Application No: EP/58/21/HH
Site Address: Mistibeech 15 Tamarisk Way East Preston BN16 2TF
Description of works: Erection of part single, part two storey rear extension with roof terrace, garden outbuilding in rear and detached garage to front following the demolition of existing sun room and roof terraces

Thank you for your internet representation made on 1st July 2021 which has been recorded as an objection with the comments as follows:

I am commenting on behalf of the East Preston and Kingston Preservation Society.

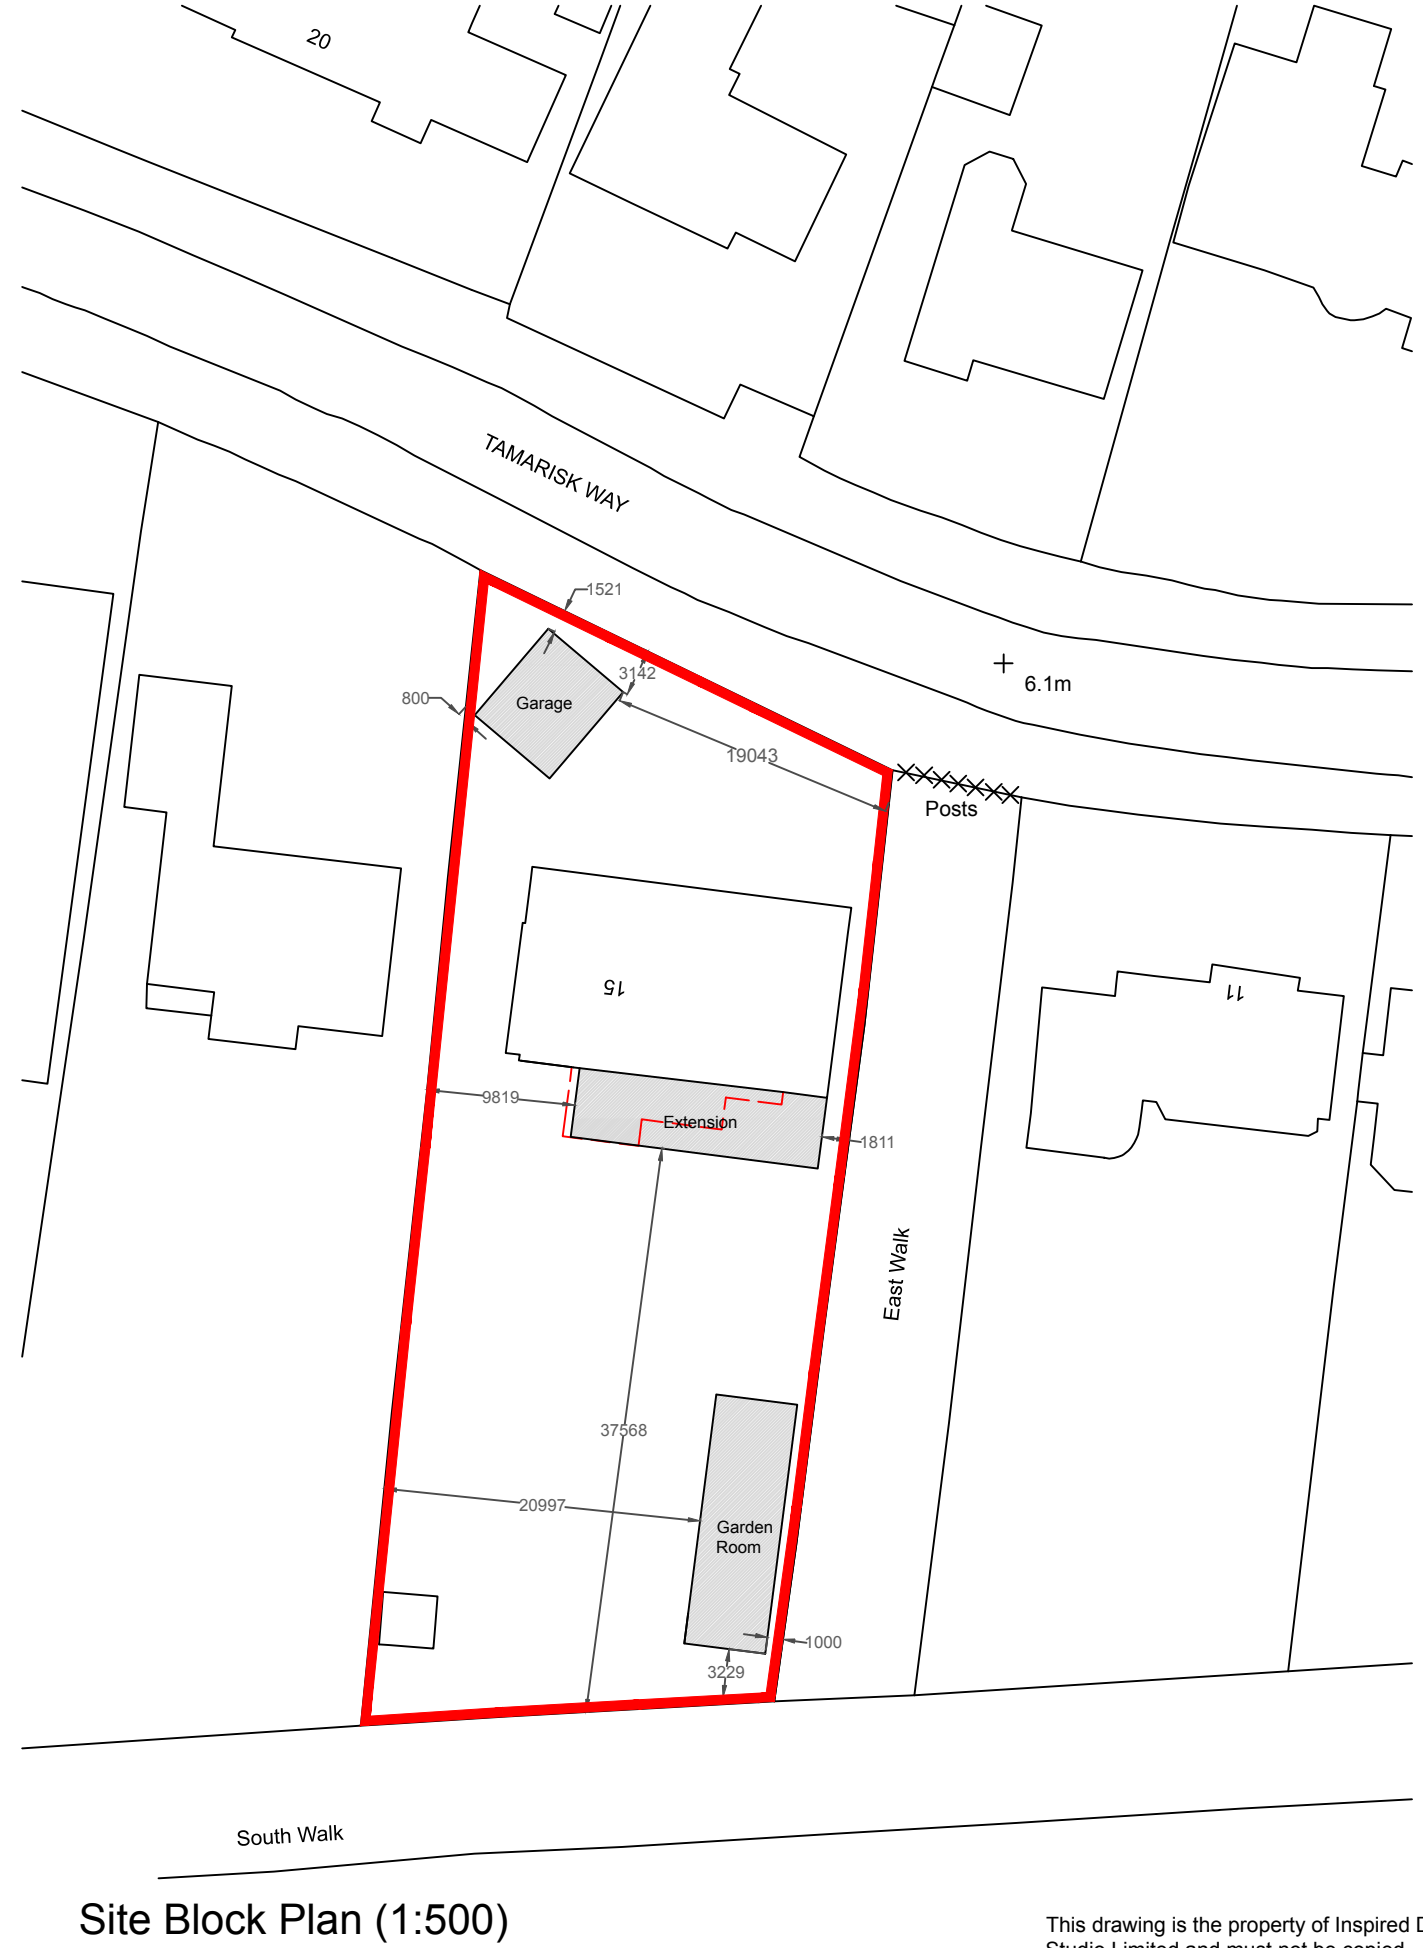
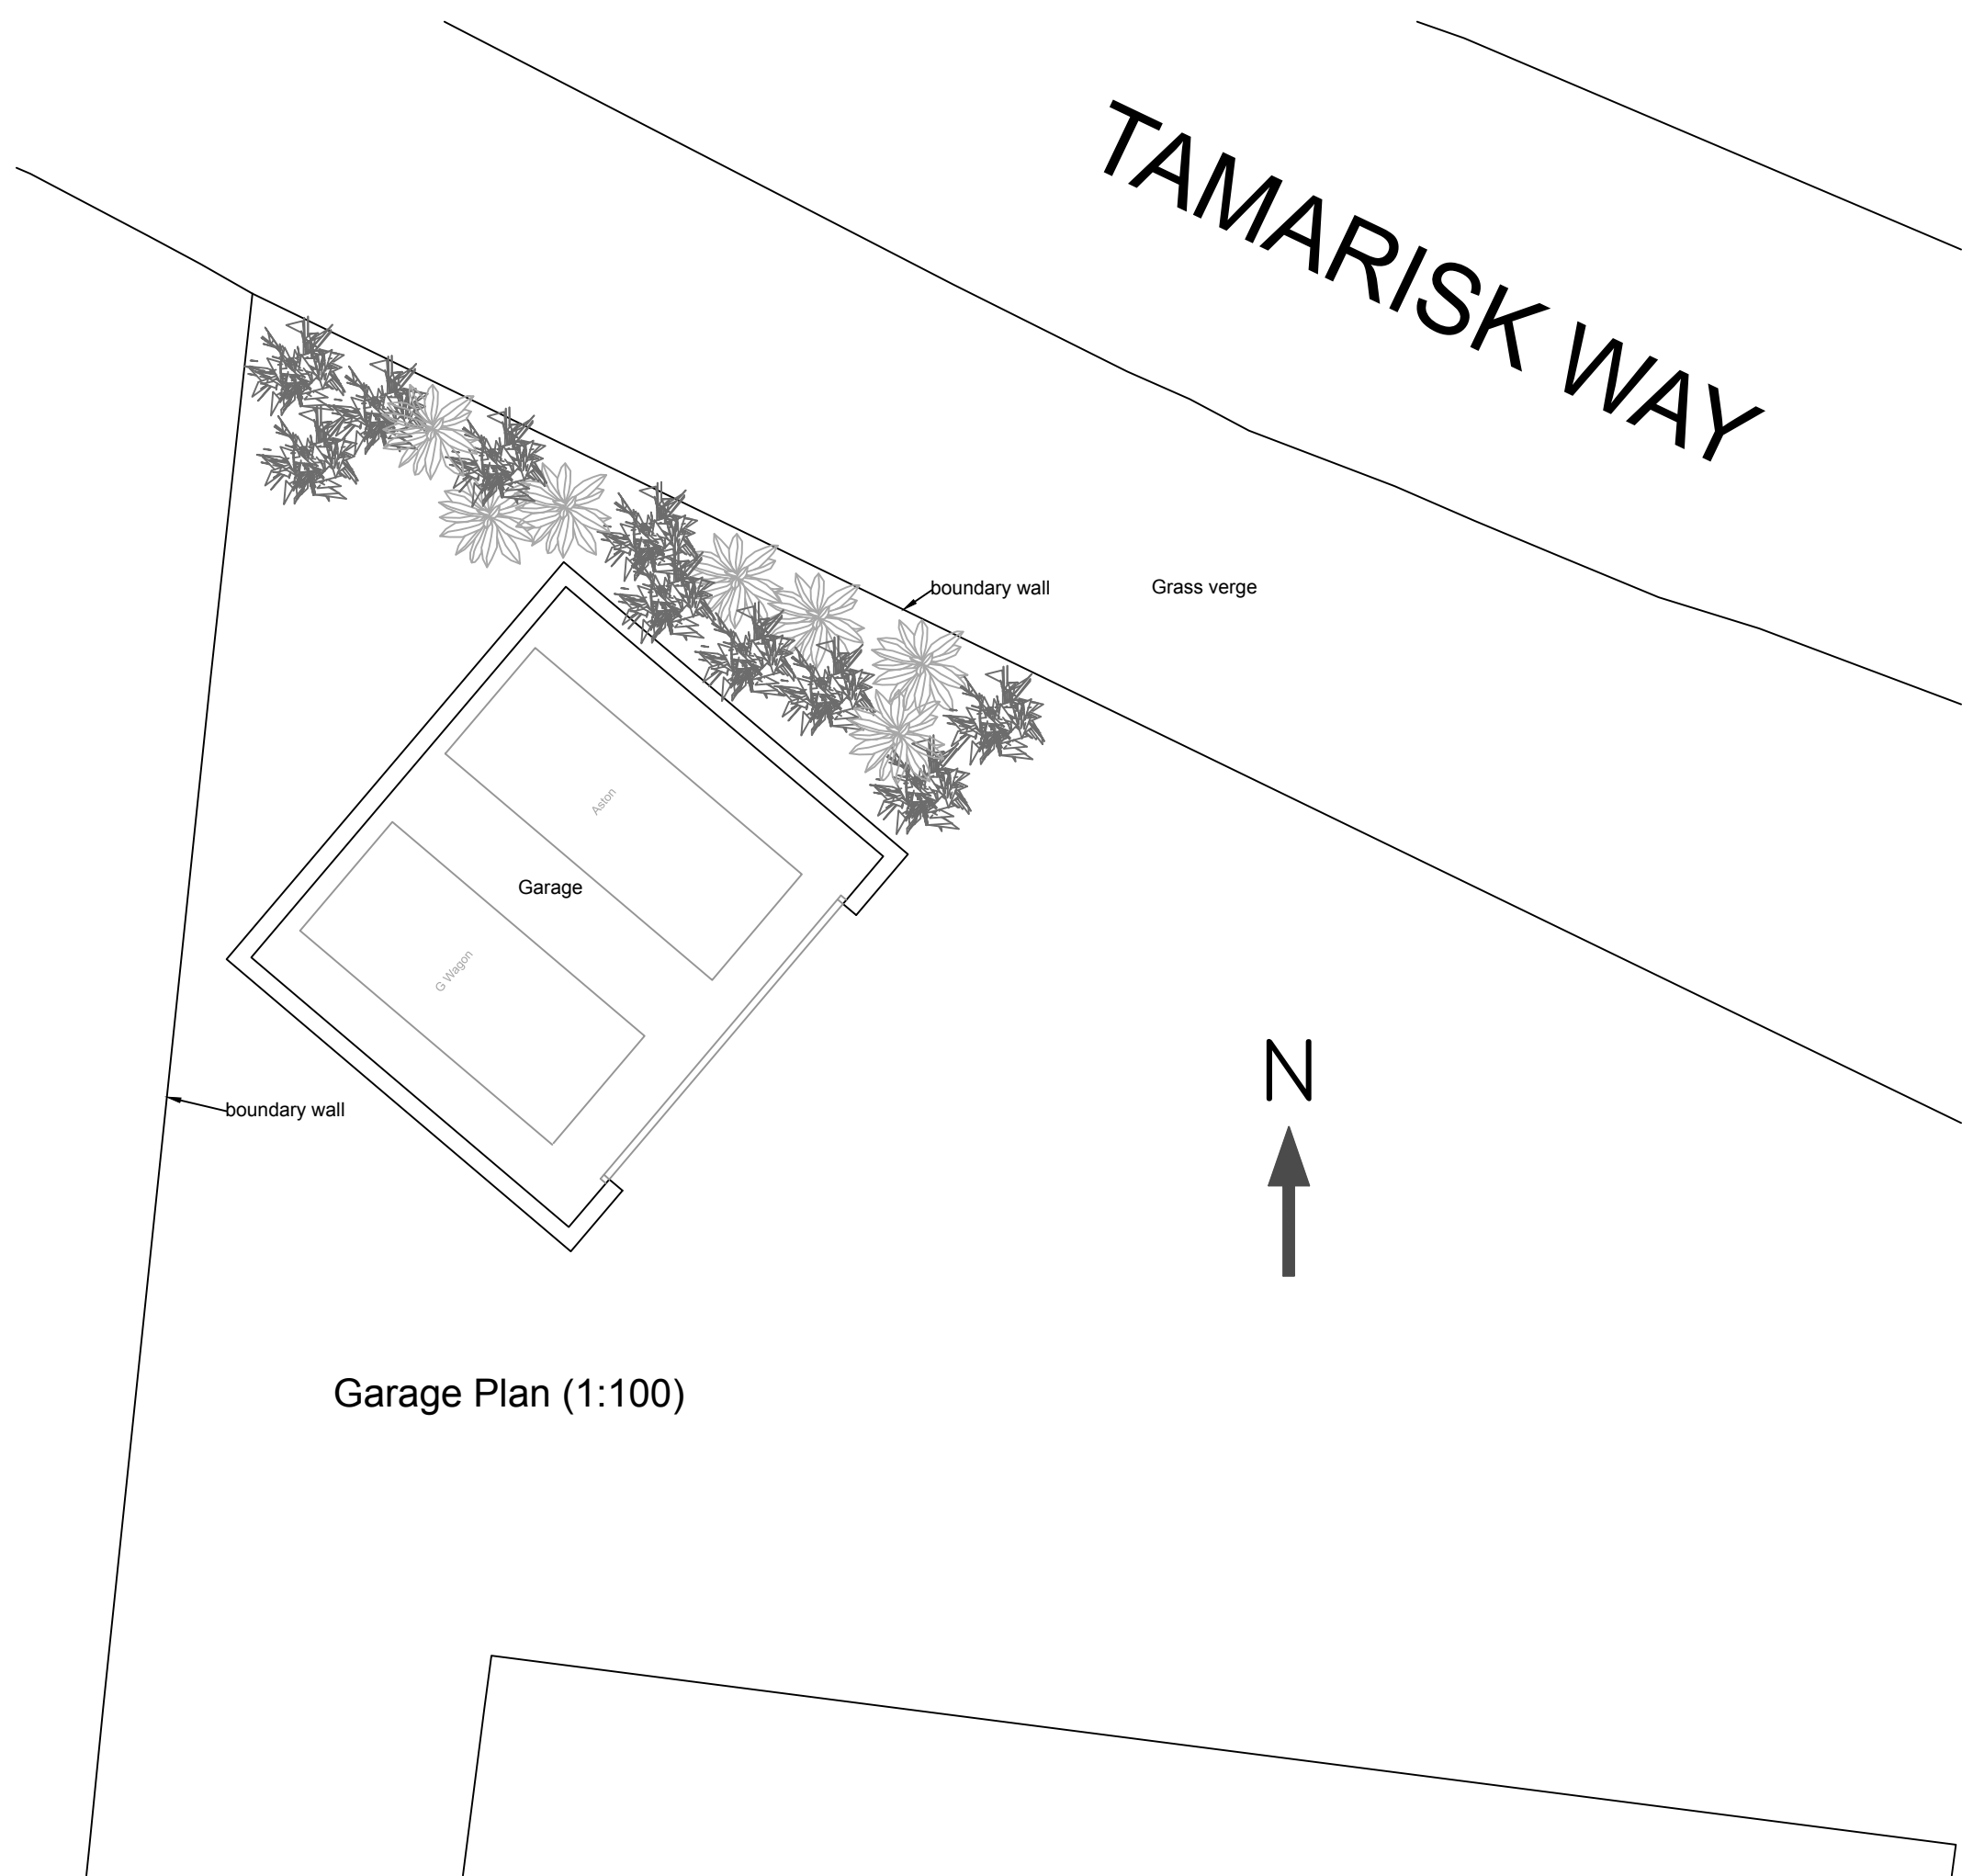
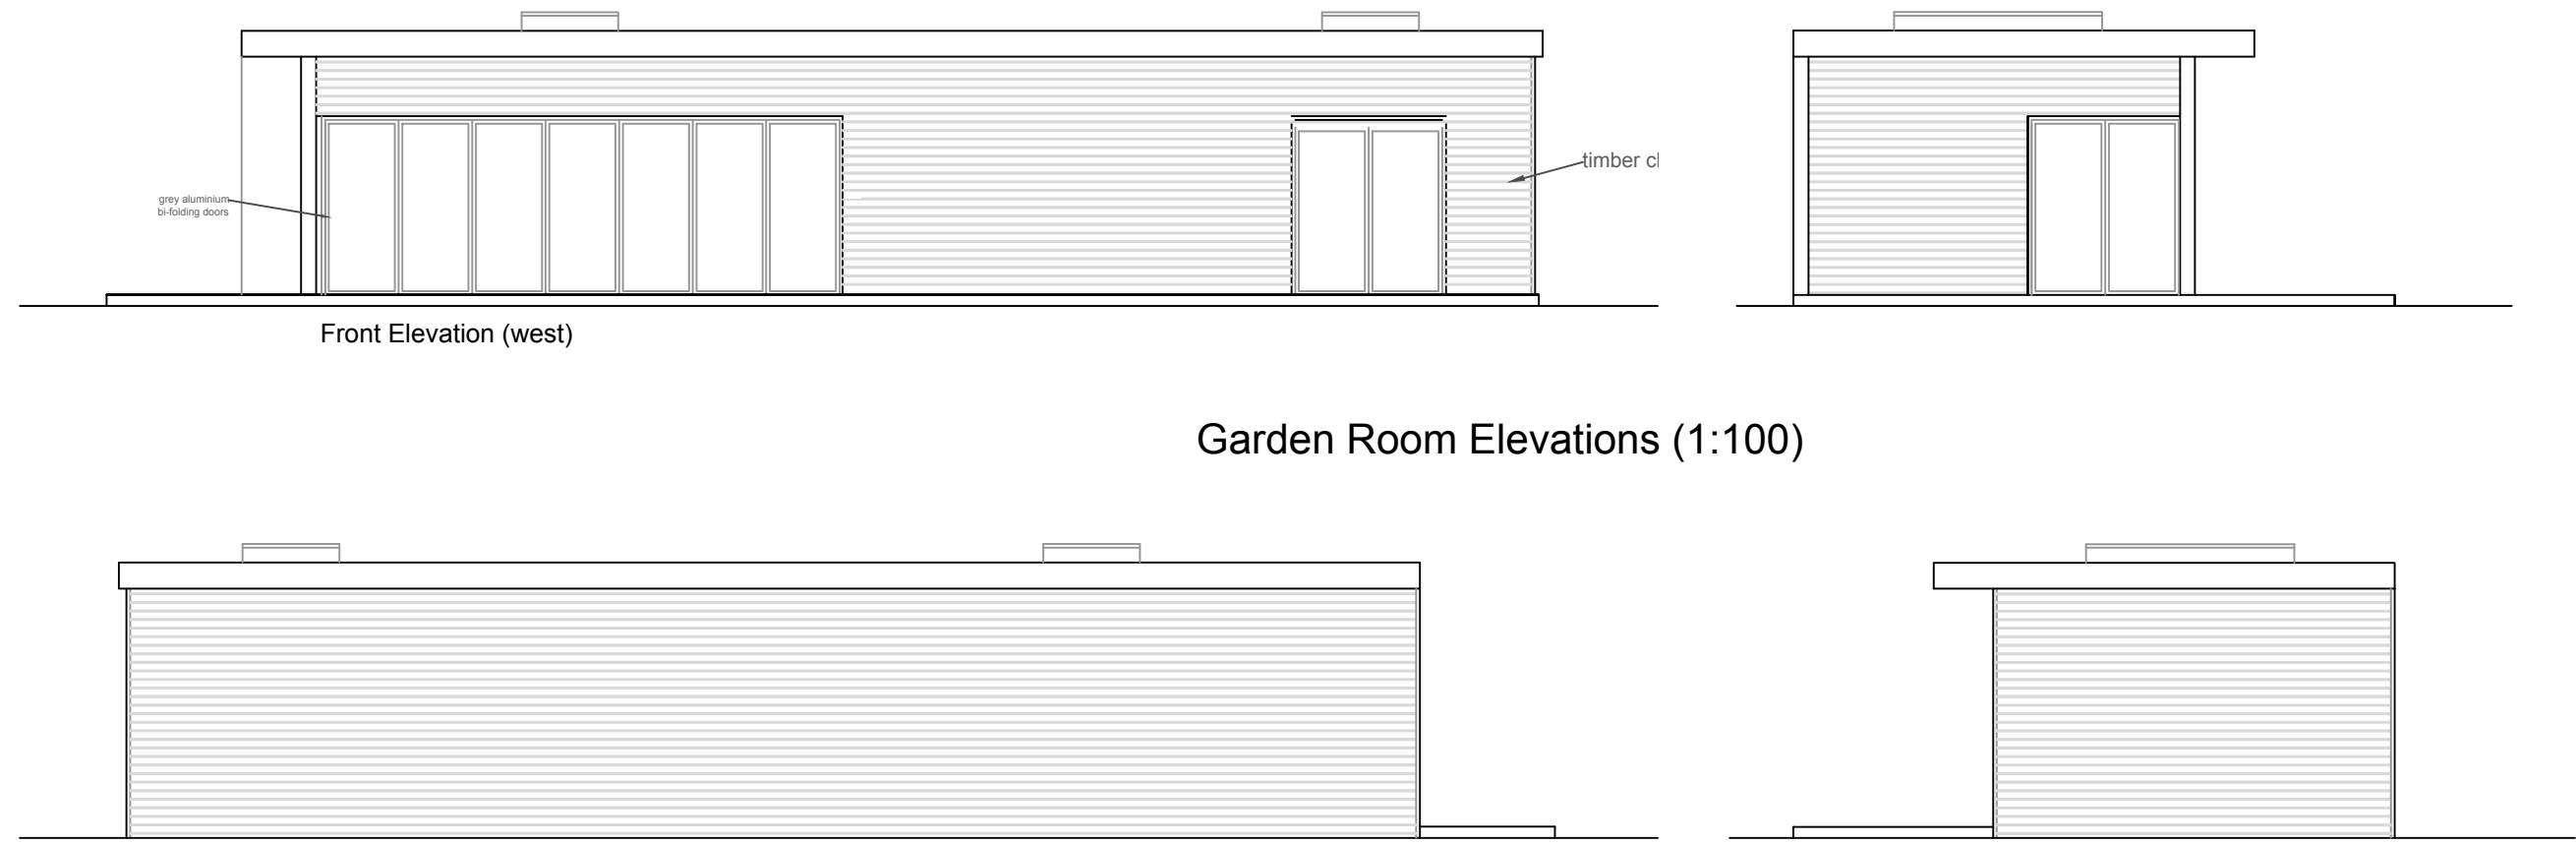
The Society does not object to the alterations to the house proposed in this application. It does, however, object to the position of the proposed garage. It would be placed between one and two metres from the the street boundary wall of the site. No other house in the road has any building positioned so close to the road. The appearance of the road is enhanced by all houses being placed well back from the road behind large front gardens, producing a green and open appearance. The proposed garage would therefore create a significant and harmful change to the street scene. The application shows shrubs between the garage and the boundary wall to screen the garage, but the gap is too narrow, at one to two metres, to provide enough space for shrubs tall enough to hide the garage to be grown.

The garage would therefore harm the street scene, and would contravene Policy D DM1 of the Arun Local Plan and Policy 2 of the East Preston Neighbourhood Plan. Planning permission should therefore be refused,
